SSD-7538: Lots 7313, 7314, 7316, 7318 & 7319 DP 1185108 and Lots 3870, 3871 & 4143 DP 757298; Broken Hill North Mine, Broken Hill; Recommencement of Operations

I refer to emails from Geoff Hender, Deputy General Manager at Perilya Broken Hill Pty Ltd on 19 and 25 July 2018 forwarding proposed amendments to haulage operations for the Broken Hill North Mine Recommencement Project.

I write to advise Roads and Maritime does not object to proposed amendments, subject to the following:

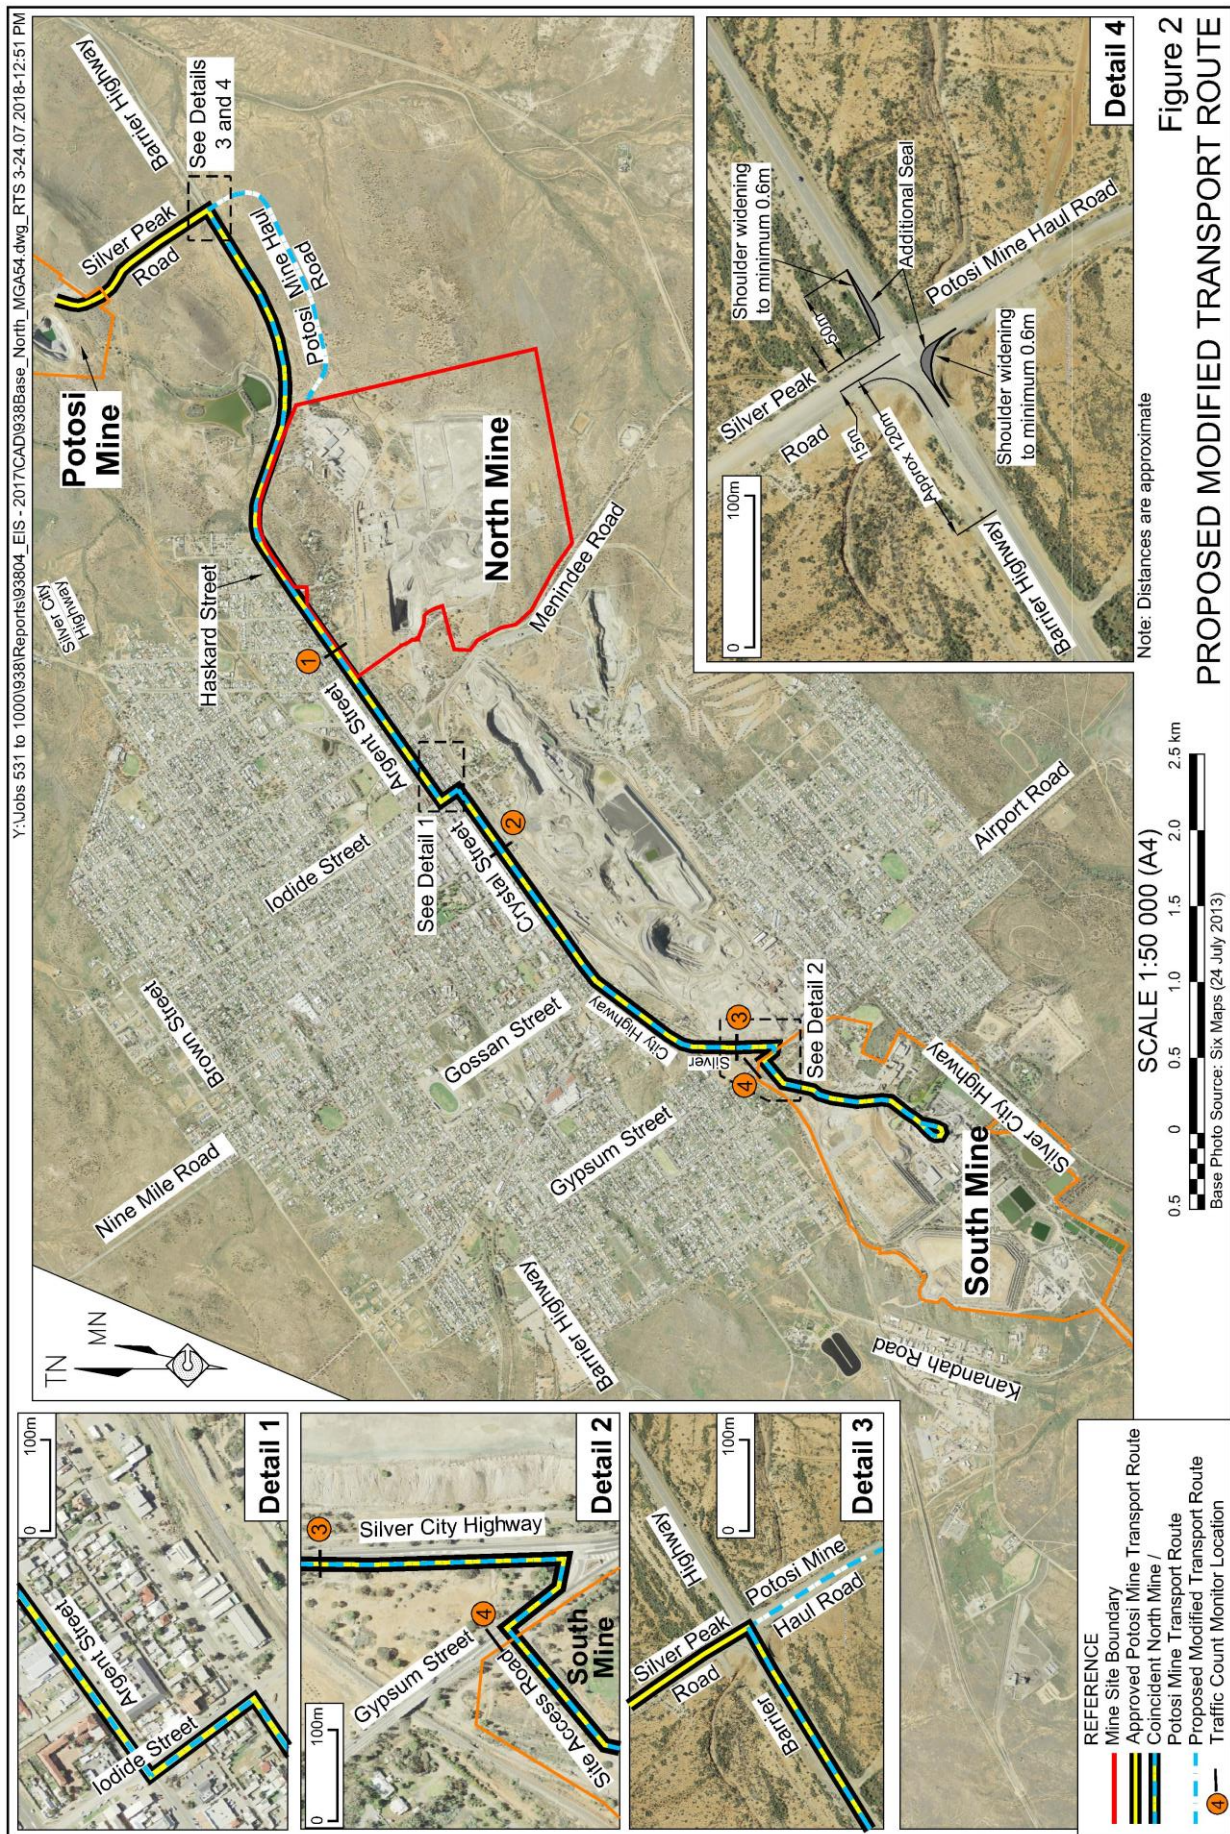
- Prior to the commencement of haulage operations, the intersection of the Potosi-North Mine haulage road and the Barrier Highway (HW5) is to be upgraded to include:

- A Basic Right (BAR) turn treatment as shown in Figure A 28 of the *Austroads Guide to Road Design: Part 4* (copy enclosed) and relevant Roads and Maritime supplements. The widened shoulder is to be sealed and built for a 110km/h speed environment to provide a reasonable level of safety for traffic turning right into the site and to allow following eastbound traffic an area to pass the right turning vehicle on the left hand side.

- A Basic Left (BAL) turn treatment as shown in Figure 8.2 Part 4A of *Austroads Guide to Road Design* (copy enclosed), and relevant Roads and Maritime supplements. The BAL facility and the access is to be sealed a minimum of 40 metres from the edge of the Barrier Highway travel lane and built for a 110km/h speed environment.

- Safe Intersection Sight Distance (SISD) requirements outlined in the *Austroads Guide to Road Design Part 4A* and relevant Roads and Maritime supplements is to be provided in both directions at the intersection. For a 110km/h speed zone the minimum SISD is 300 metres.
